## Engineers Comments Regarding Surface Water Drainage

| <b>Application Reference:</b>   | P/59/25/DOC                                                                                                                                   | <b>Reviewer Reference:</b> | ADC/EXT2/D2134/74 |
| <b>Site Name:</b>               | Sefter Farm Pagham Road Pagham PO21 3PX                                                                                                       |                            |                   |
| <b>Application Description:</b> | Approval of details reserved by condition imposed under reference P/117/21/PL relating to condition number 7 - surface water drainage scheme. |                            |                   |

CLIENT		Barfoots Of Botley	
PROJECT		Sefter Farm East	
TITLE		Proposed Site Sections - Sheet 2	
DRAWN	DATE	PROJECT NO.	
A Davies	May 2025	24019	
ENGINEER	CHECKED	DWG. NO.	REV.
S Doughty	SRM	312	-
SCALE	NTS

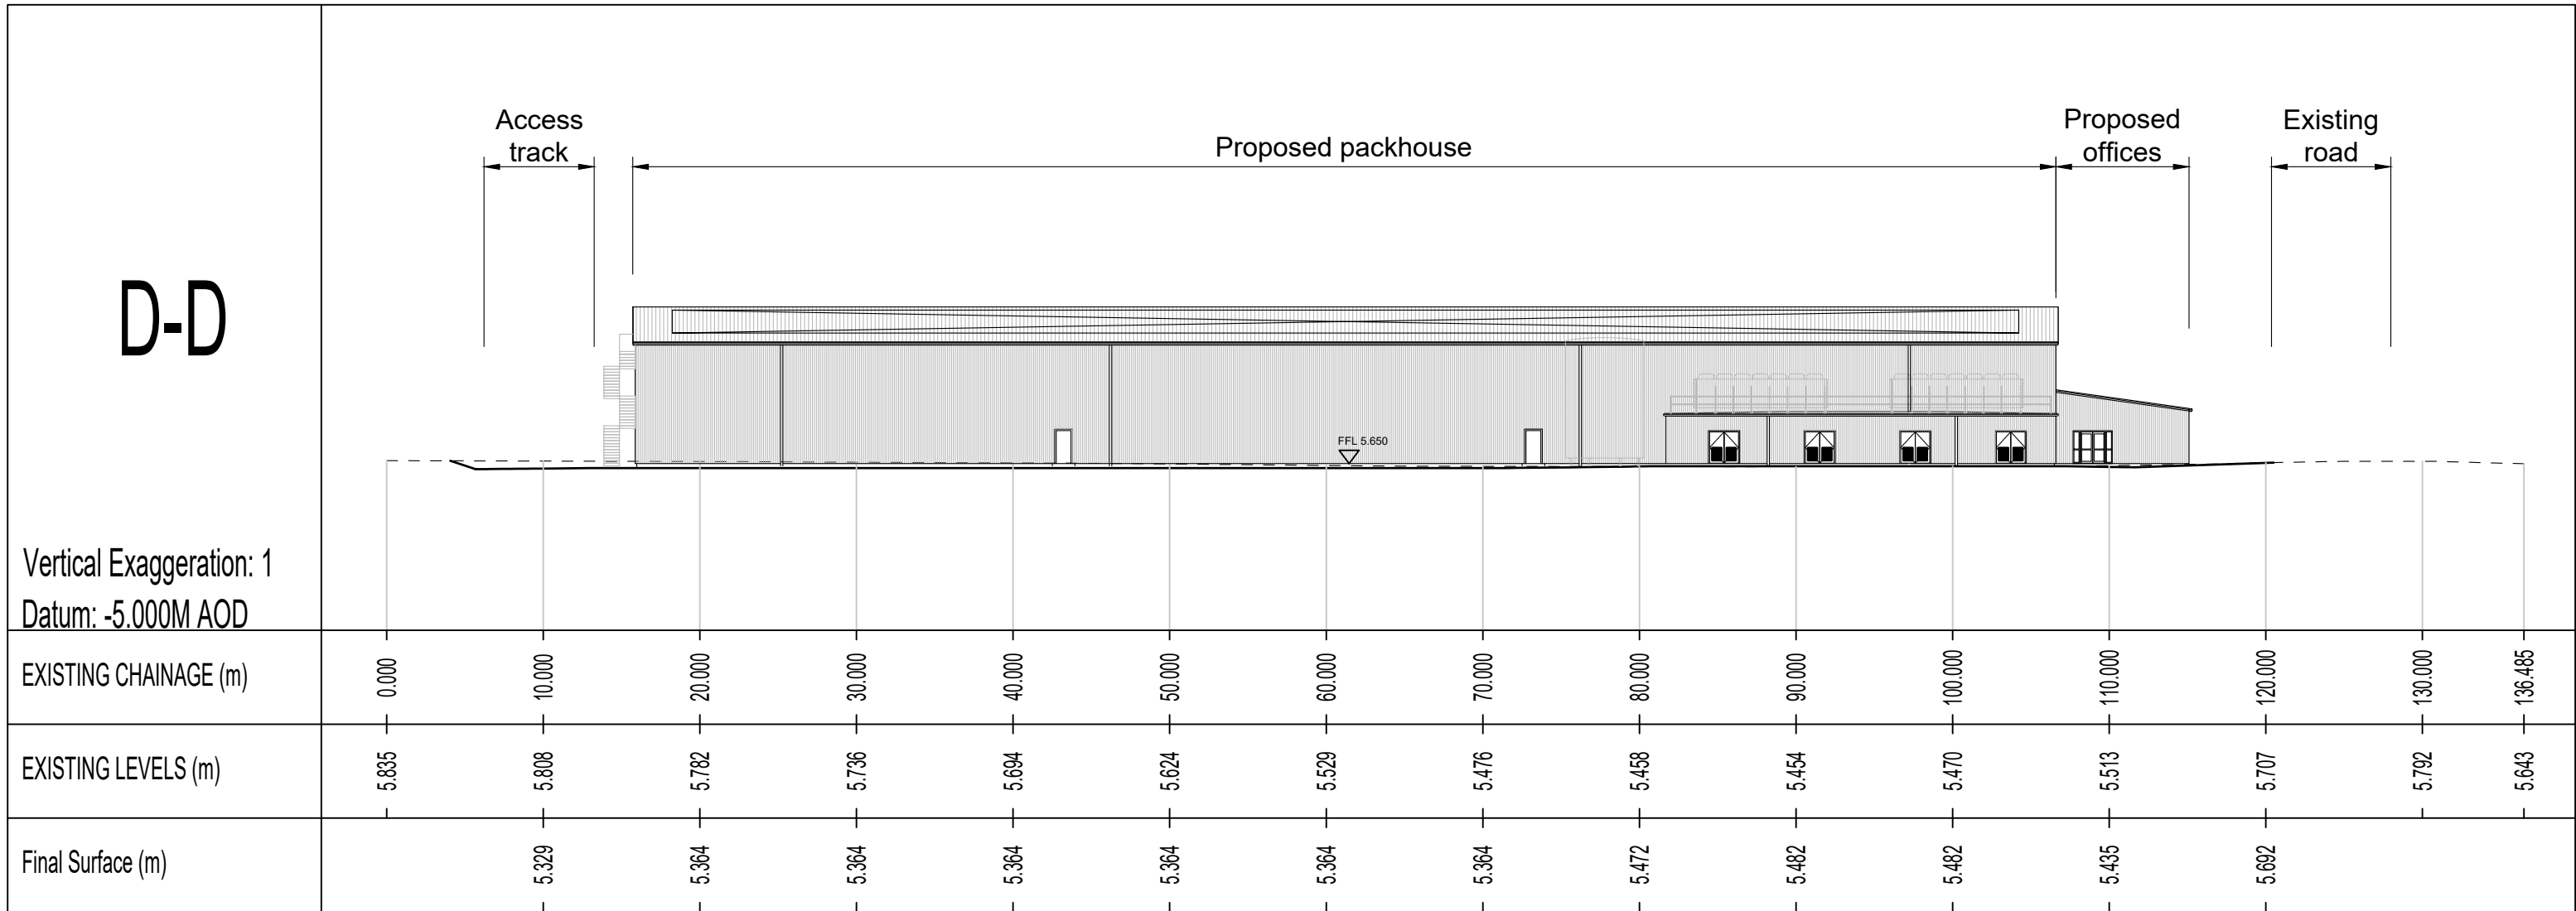
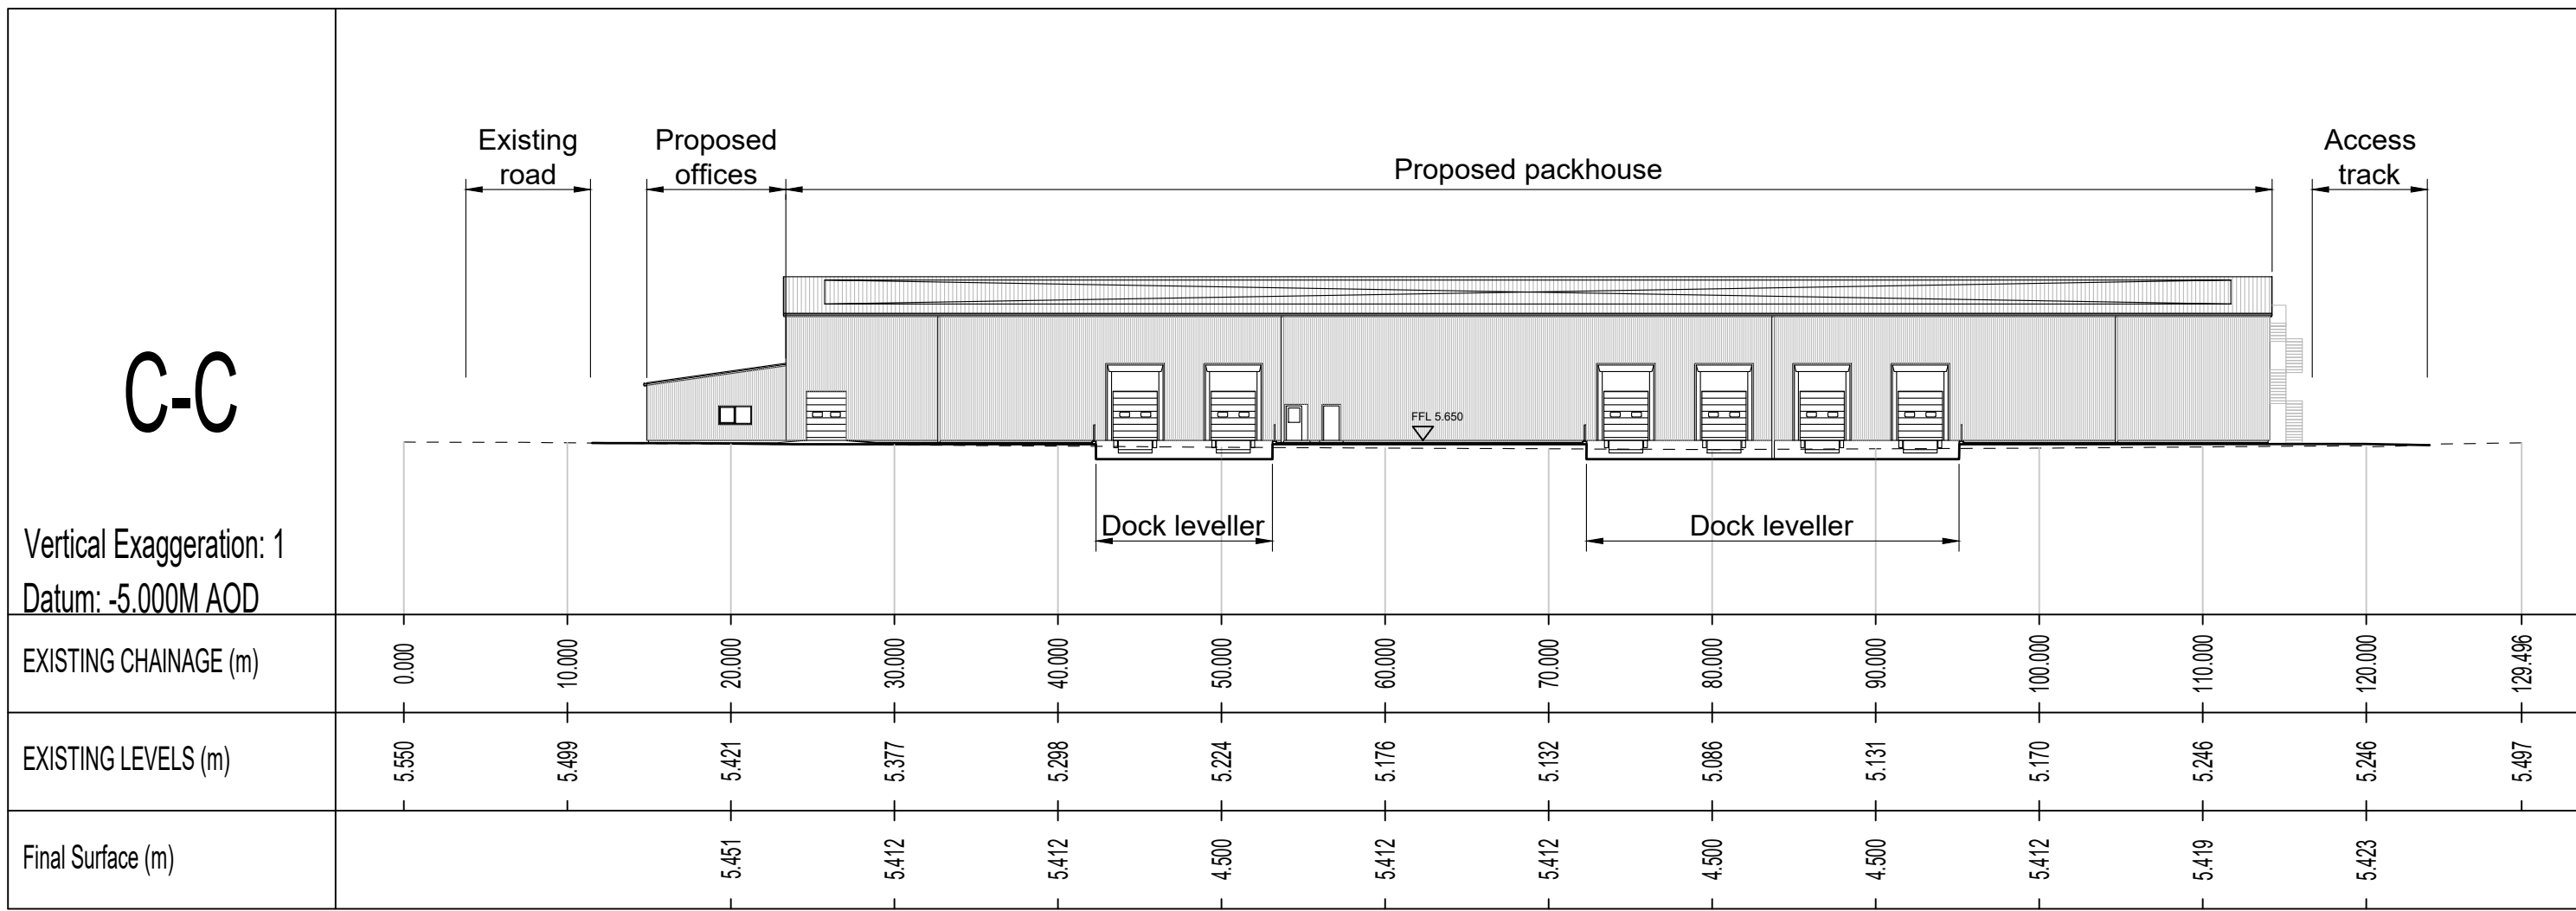
| 9.  | Whilst the proposed yard and permeable parking are proposed to be laid very flat, the site sections nor surface finishes highlight any boundary kerbs/edging which may have a role in controlling run-off, please confirm.                                                                                                                         |  |  |  |  |
